City of Albuquerque Stormwater Construction Site Inspection Report

ESC File No.	K14E017	Project Name:	Legacy Central and Broadway Hotel		
NPDES Id. No.	NMR1001MD	Location:	SW Corner of Central and Broadway		
5/18/2021	Owner	Contractor			
Operator	Legacy Hospitality	Kassam Construction, LLC			
Contact name & title	Faisel Kassam	Matt Ferreira			
e-mail	fkassam@legacy-hospitality.com	mferreira@kassamconstruction.com			
Contact Phone #	505-243-6000	505-415-4568			
COA Inspector	Thomas Evans	Start/End Time:	2:05 PM/3:00 PM		
Construction Phase:	Building construction, flatwork				
Type of Inspection:	Regular	Storm Event	Past Storm Event >0.25"	311/Complaint	Follow Up
Weather at time of inspection?	rain	Temperature:	~ 54		
Estimated date of last storm 0.25" or greater	5/3/2021

EROSION AND SEDIMENT CONTROL PLAN

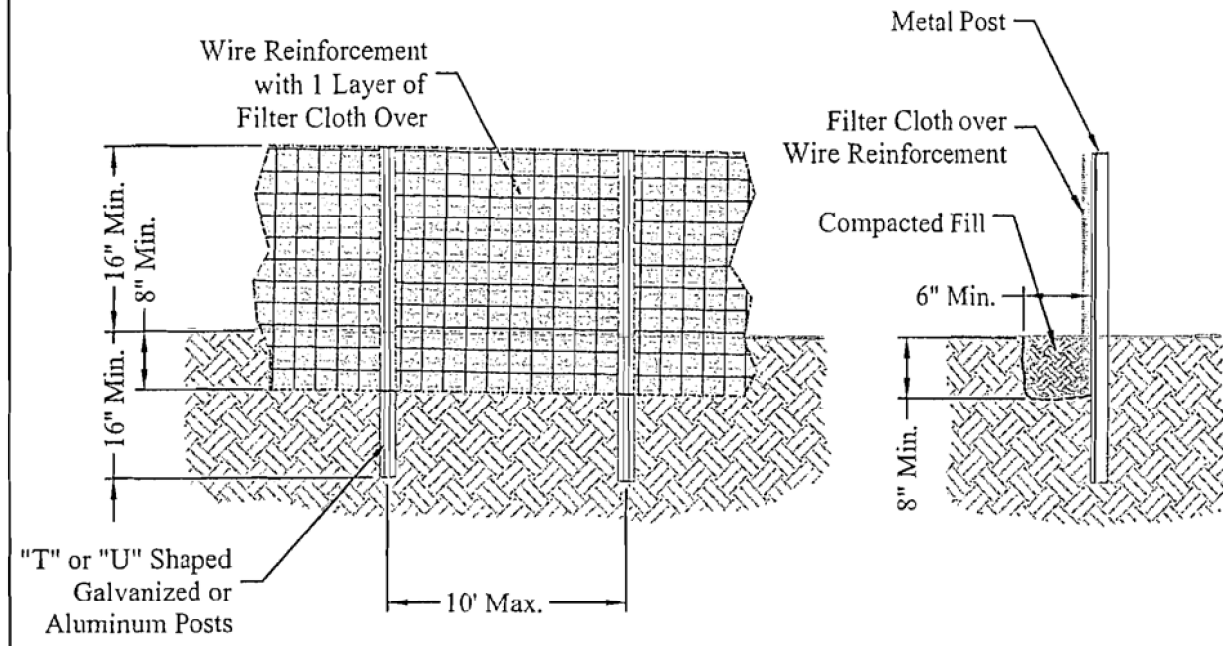
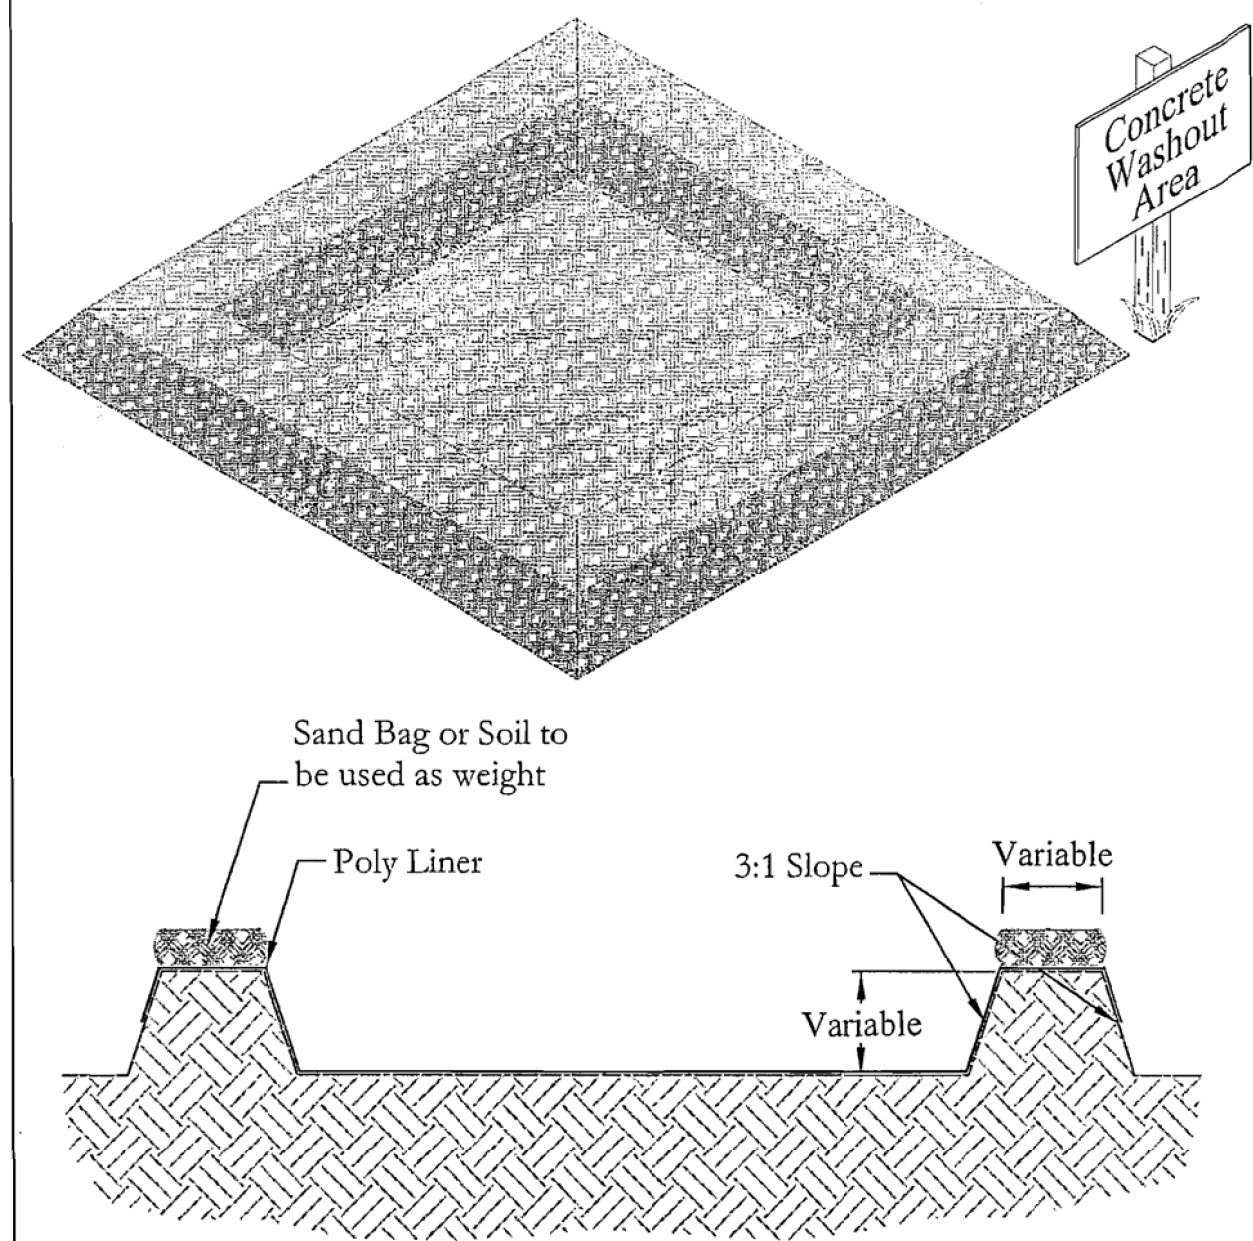
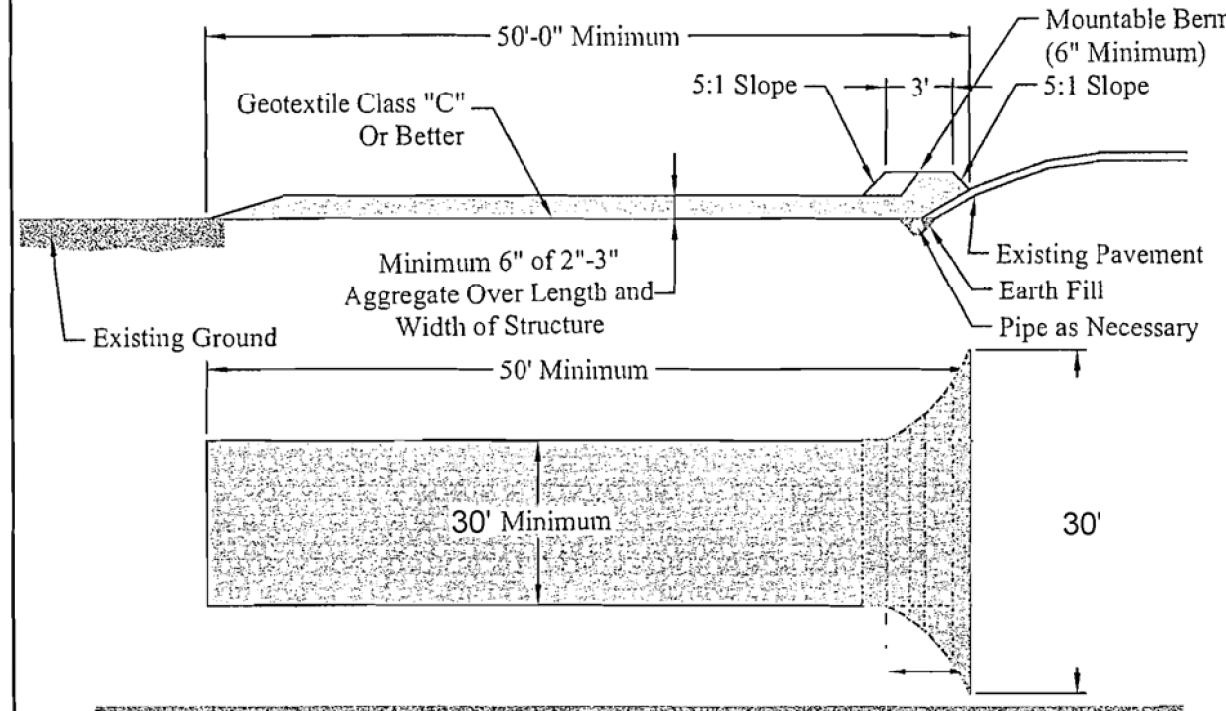
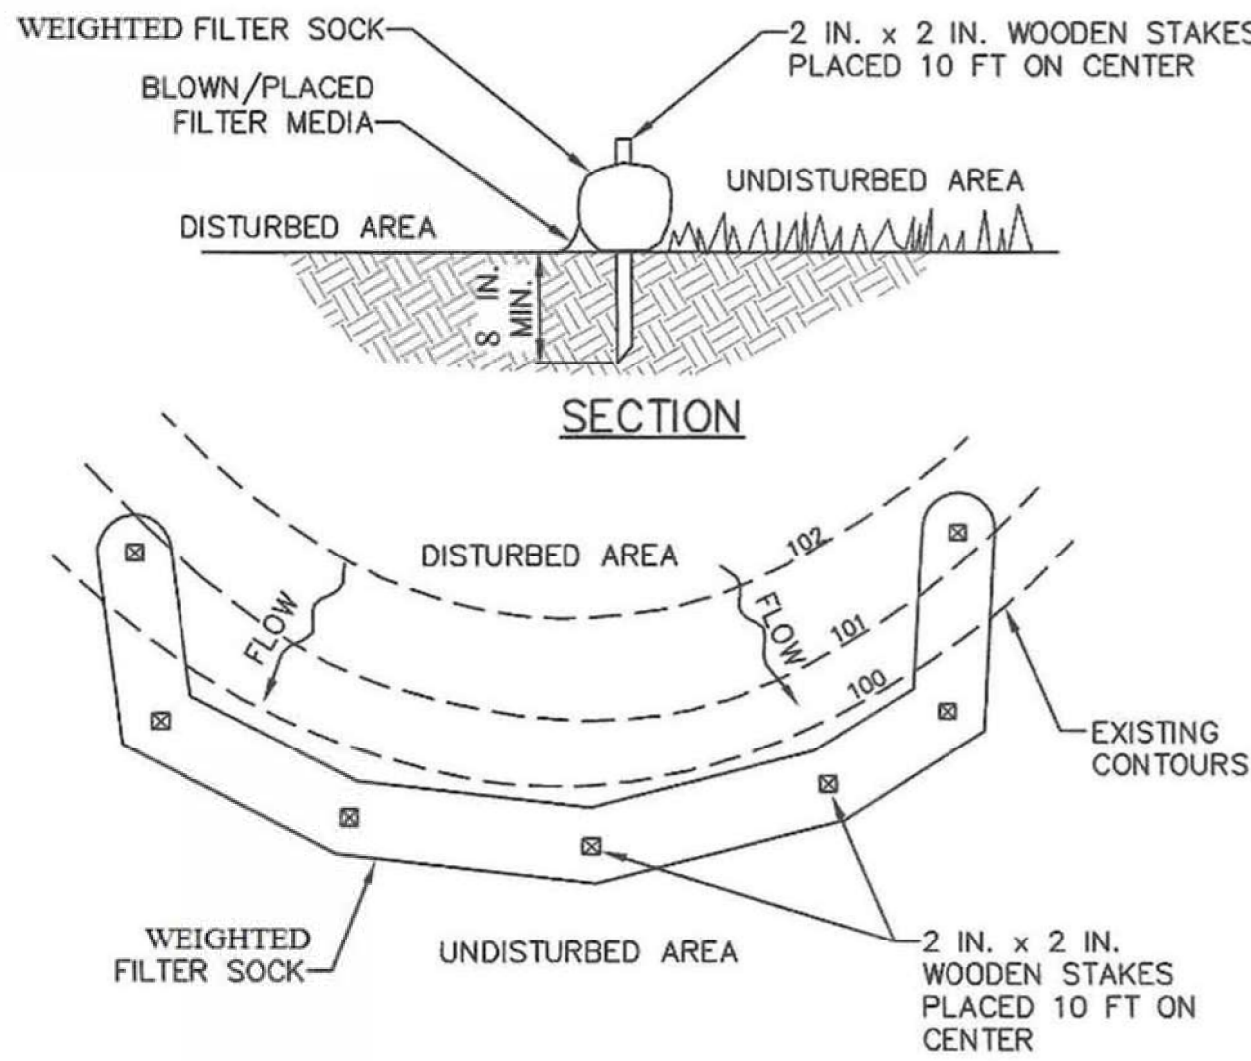
Item Number	Deficiency/ Corrective Action				
1	Sediment in west channel. Remove accumulated sediment daily from the channel on the West side of the site and from the streets.				
2	No posting NOI permit coverage. Post signage of NOI permit coverage in a location clearly visible to the public.				
3					
4					
5
